Transport

MAJOR PROJECT APPLICATION - ALBERT AVENUE AND THOMAS STREET, CHATSWOOD

I refer to your email dated 15 July 2010 regarding the preferred project report for the above Mixed Use Development (MP09_0066). Transport NSW appreciates the opportunity to comment on this application.

GROUND FLOOR PLAN

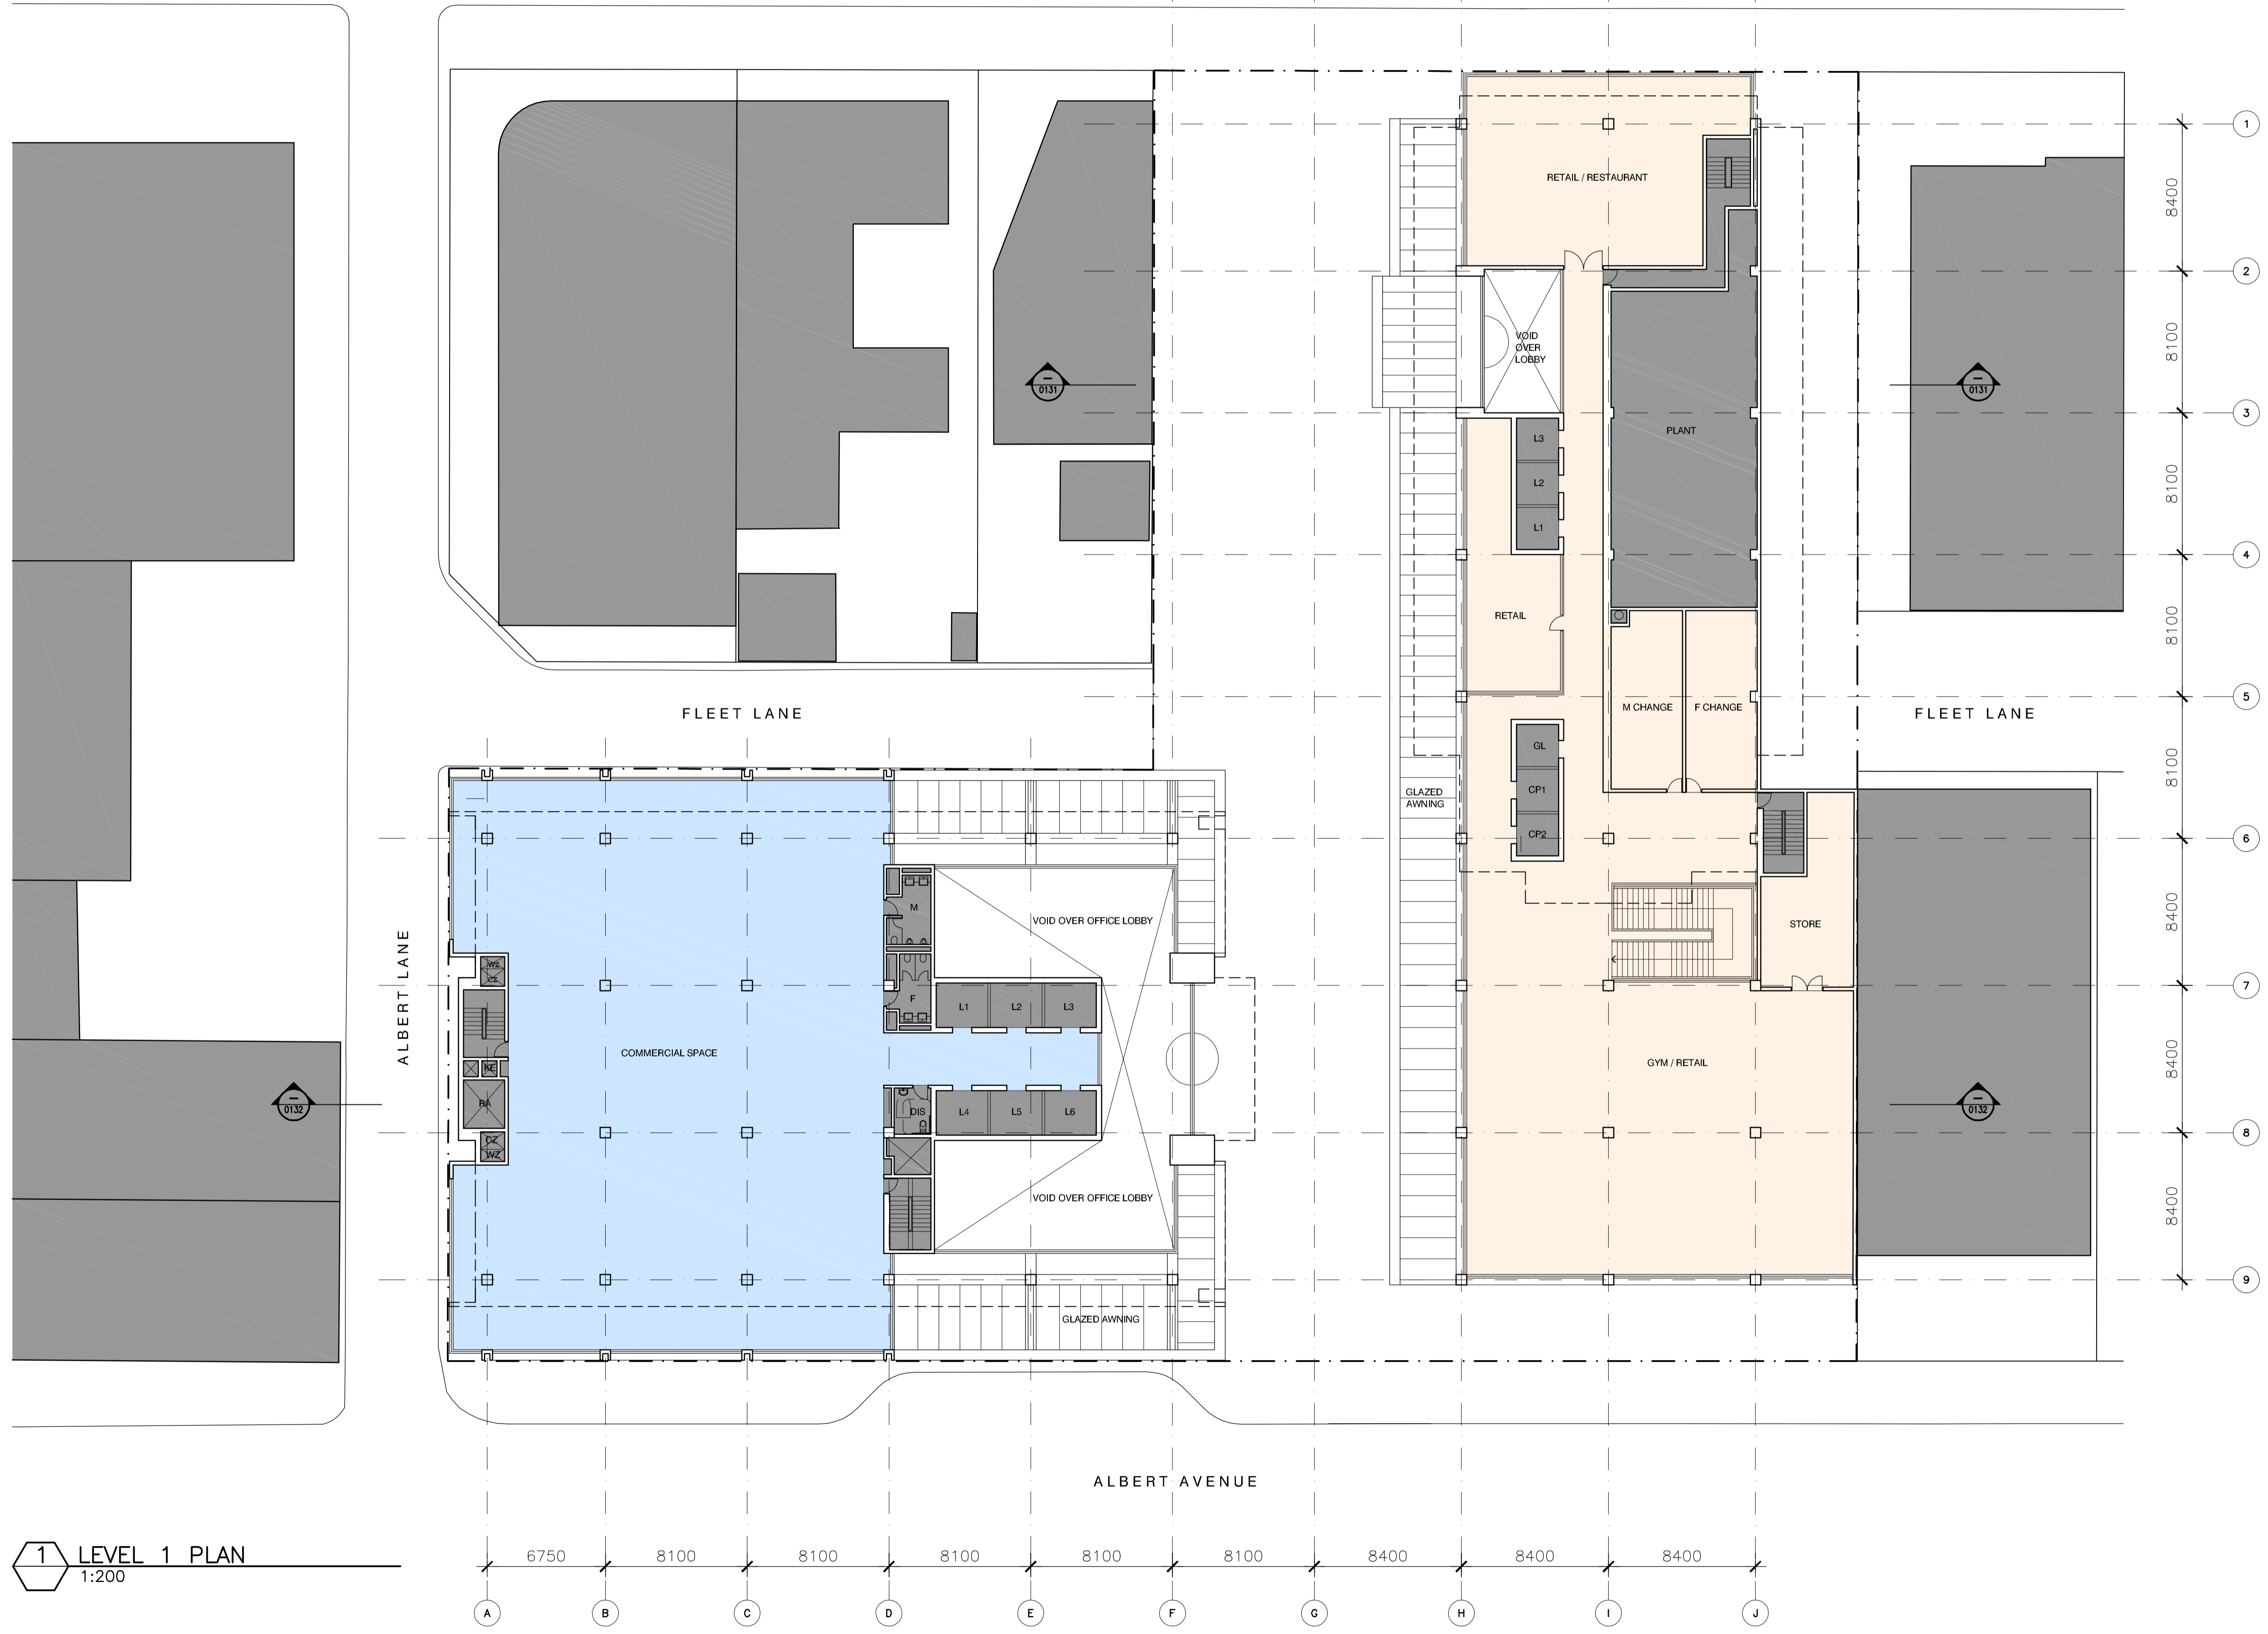
5. Transport NSW requests the provision of visitor bicycle parking facilities at ground level close to retail entrances, in a visible and weather protected location, in addition to resident and employee bicycle parking on basement level.

BASEMENT 1 PLAN

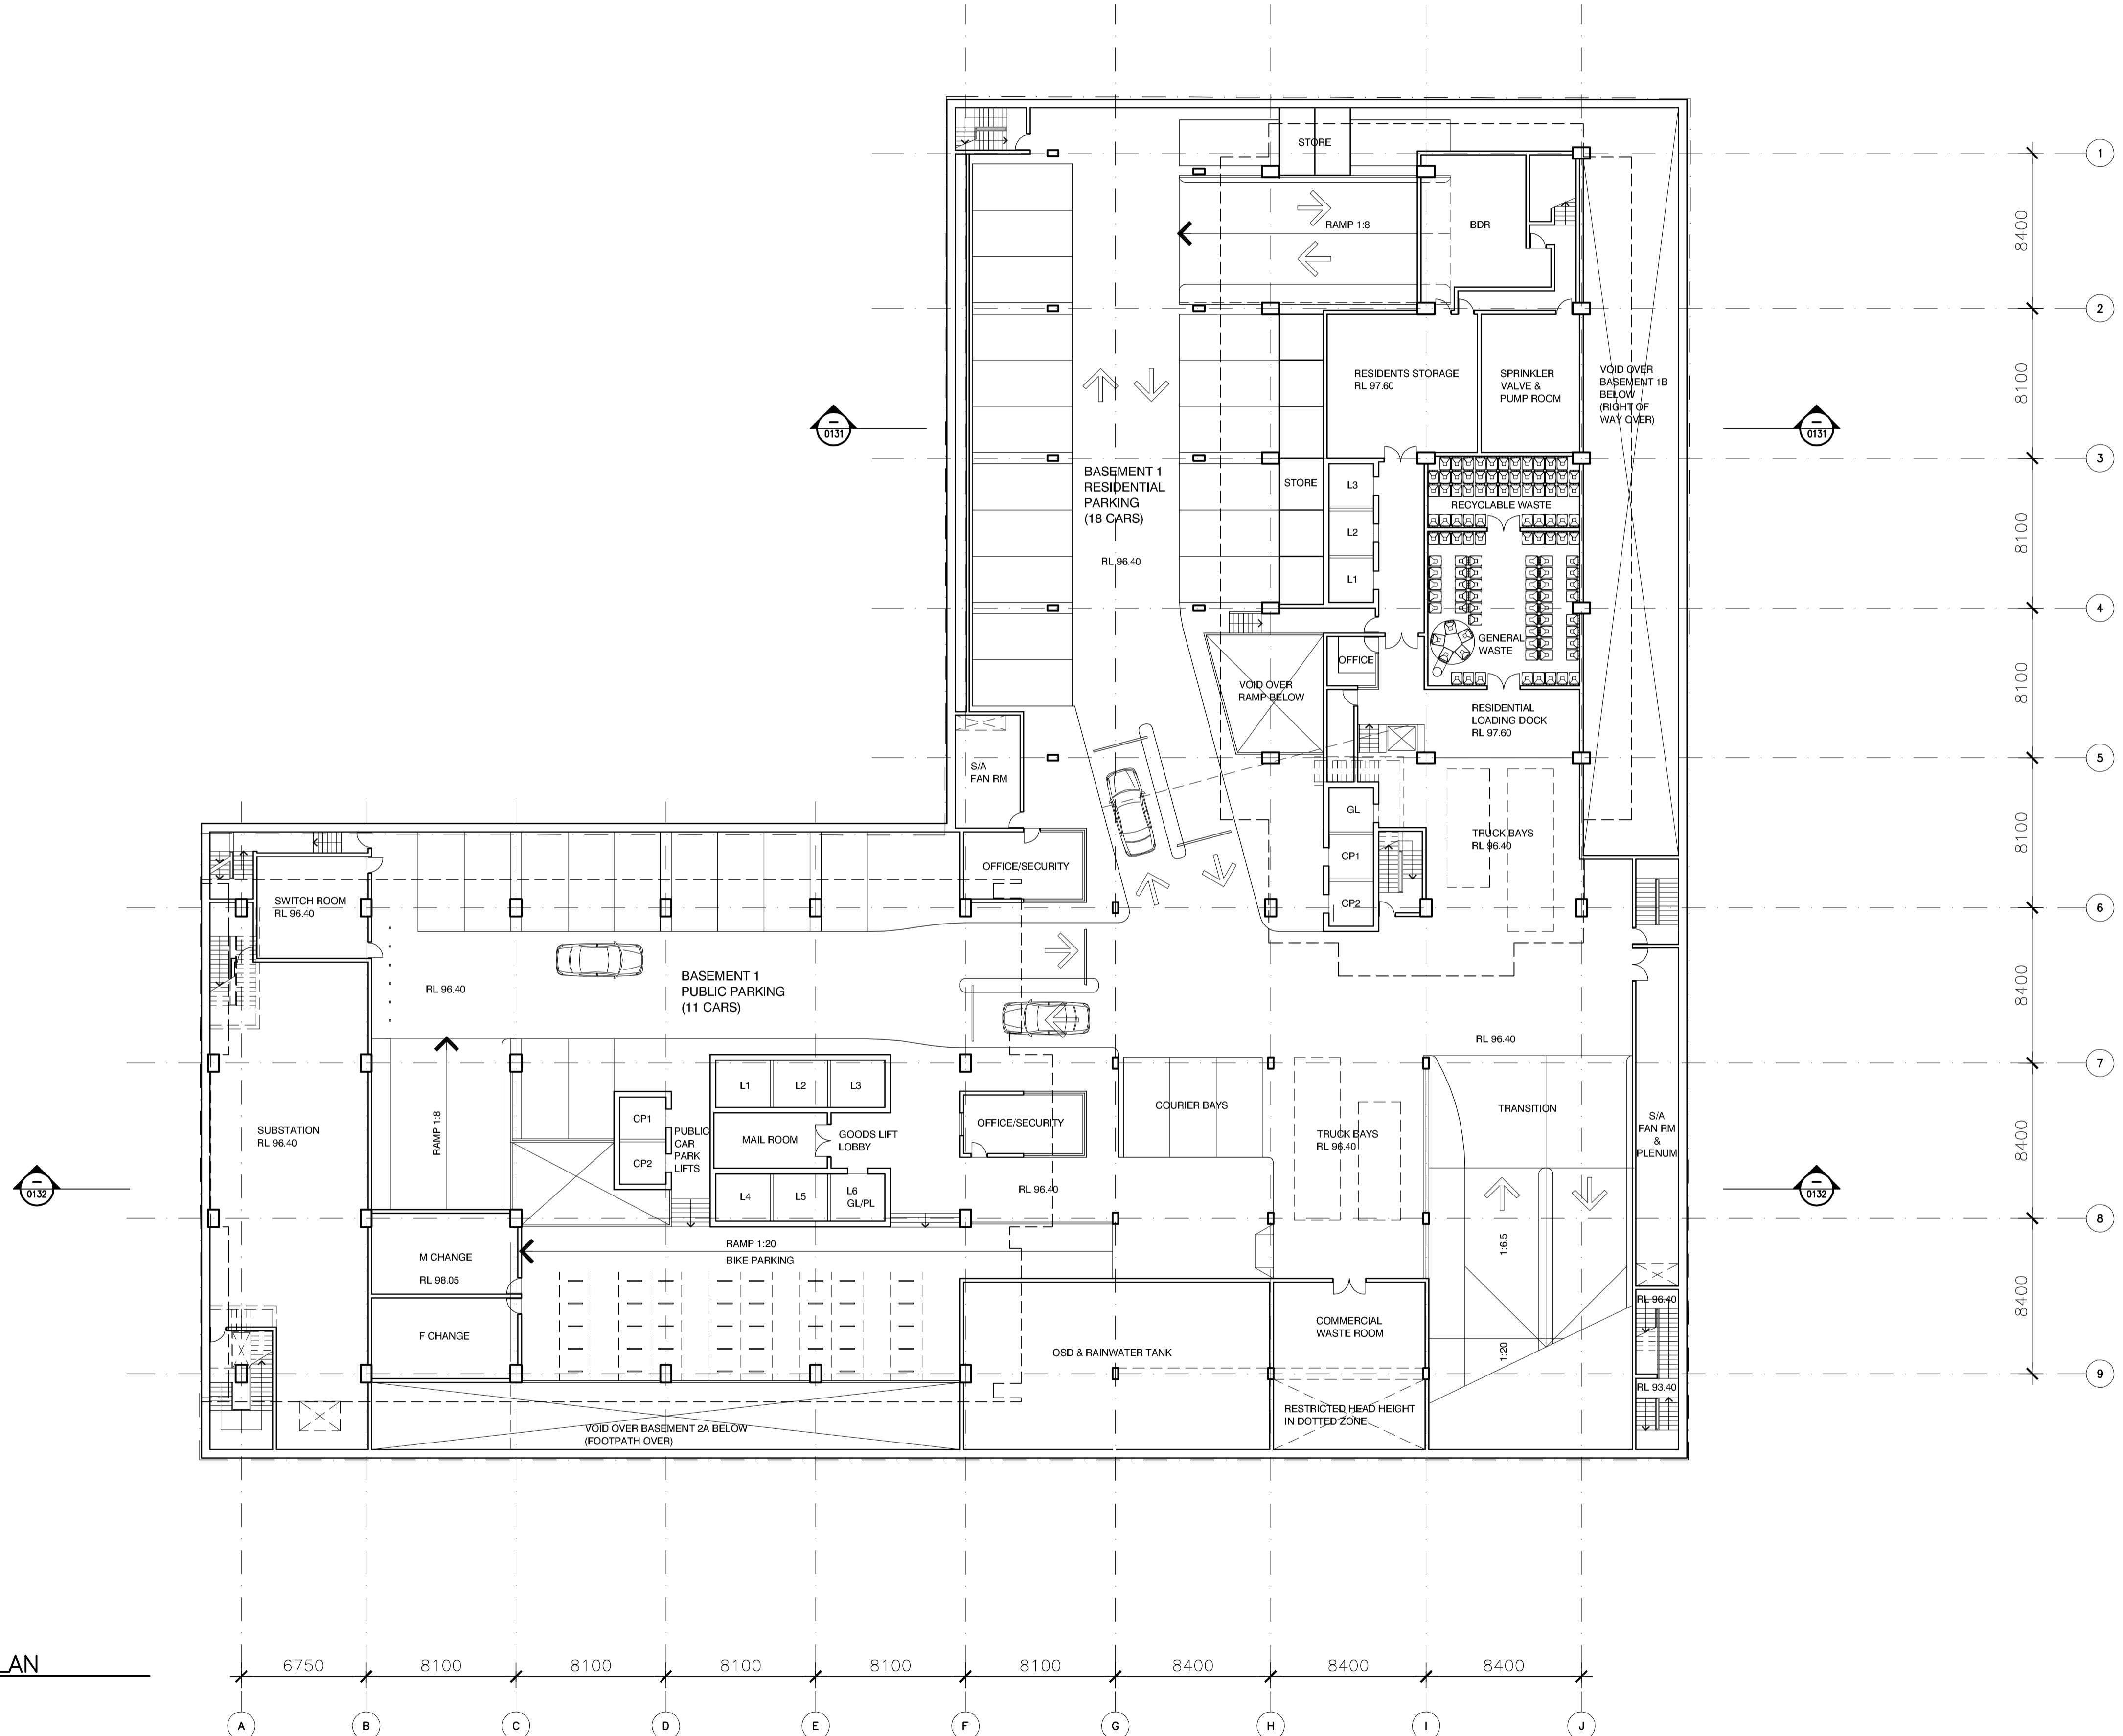
Transport NSW has reviewed the preferred project report and notes the provision of bicycle facilities on the first basement level and the commitment to prepare a Green Travel Plan. Detailed comments on the proposal are:
